Your Ref: OWPC23661
Our Ref: AB/63/19/PL 19-06-2019
Please ask for:
Zac Denton

Creation of new front door - This application may affect the character and appearance of the Arundel Conservation Area.

Flat 4, The Old Warehouse Arun Street Arundel

Proposed Front Elevation

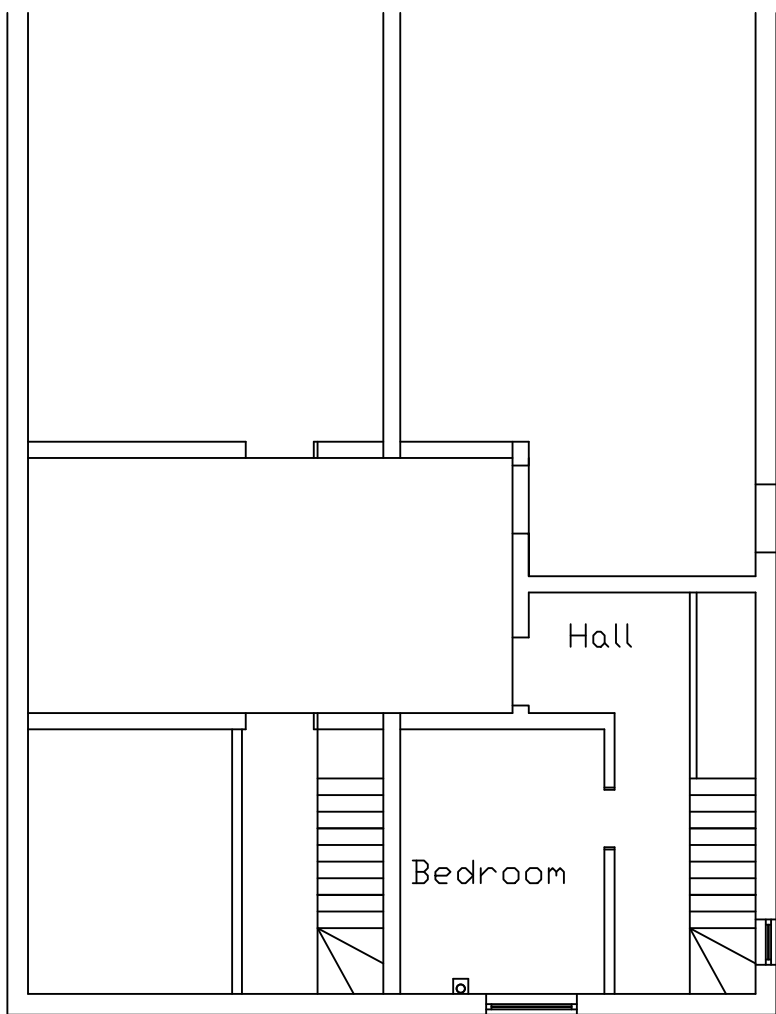
*I wish to object to this proposal of which I was only made aware by a neighbour because to date 10/7/2019 no planning notice has been displayed in the area.
This proposal is out of keeping in a conservation area and is likely to set a precedent allowing the neighbouring flat to do likewise totally altering the look of the building.*
